Your Ref: OWPC6922
Our Ref: R/215/15/HH 24-08-2015
Please ask for:
Mr D Easton

Demolition of sunroom & erection of two storey rear extension
28 Park Drive Rustington

client	project	drawing	date	drawn	drawing no	revision
Ian Dudley & Jane Tomsett	New Extension at 28 Park Drive Rustington, BN16 3DY	Proposed Elevations	Jul 15	pd	0186 / 103	B
			scale 1:100 @ A3	CAD file name:

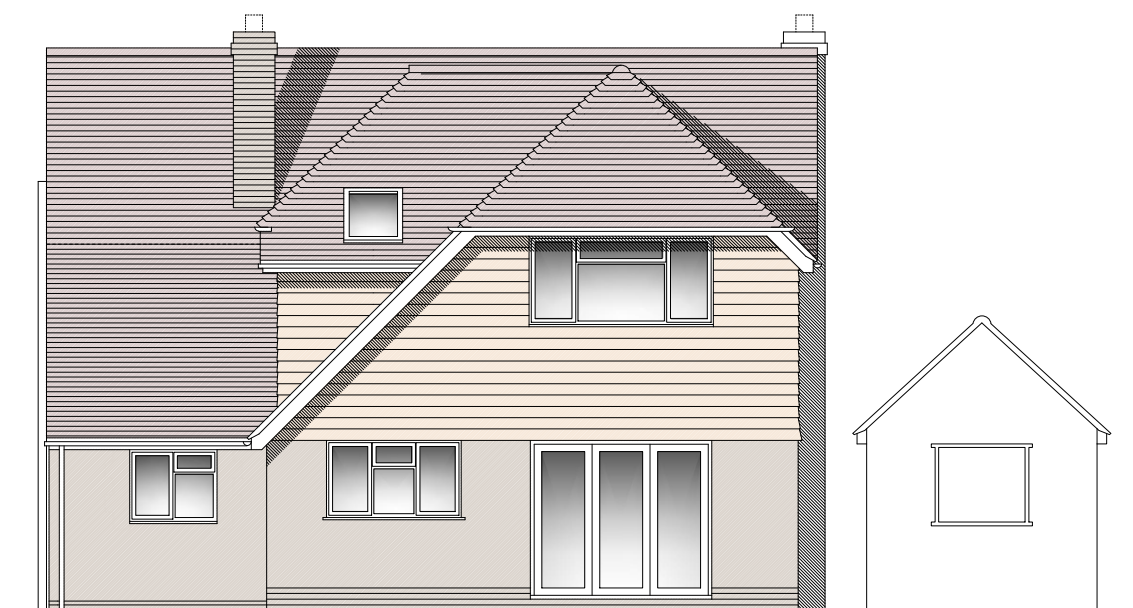
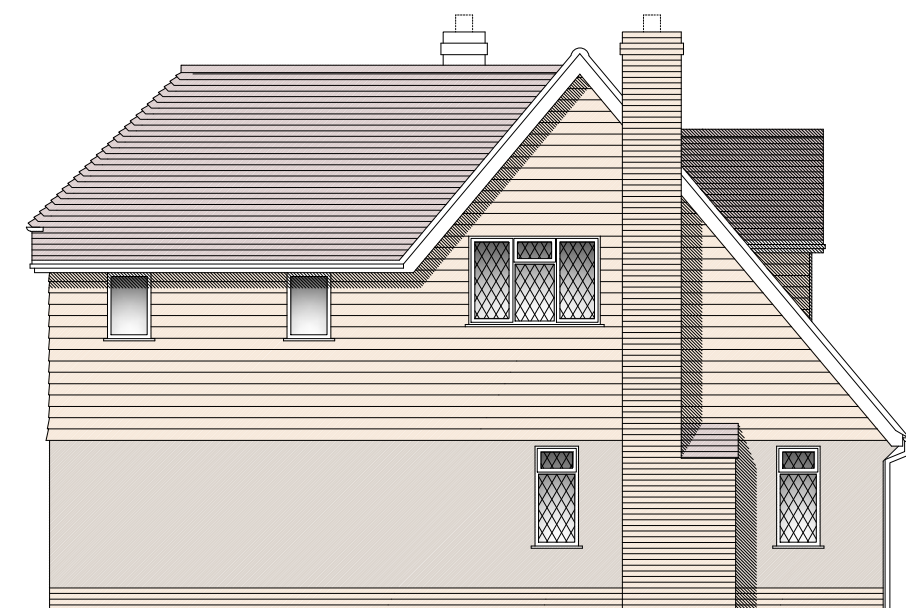
May consideration be given that we will be totally overlooked. As we are just a bungalow and it will be one large window in front of us over looking our garden, leaving us no privacy. If no alternative can be found - could frosted glass be installed.
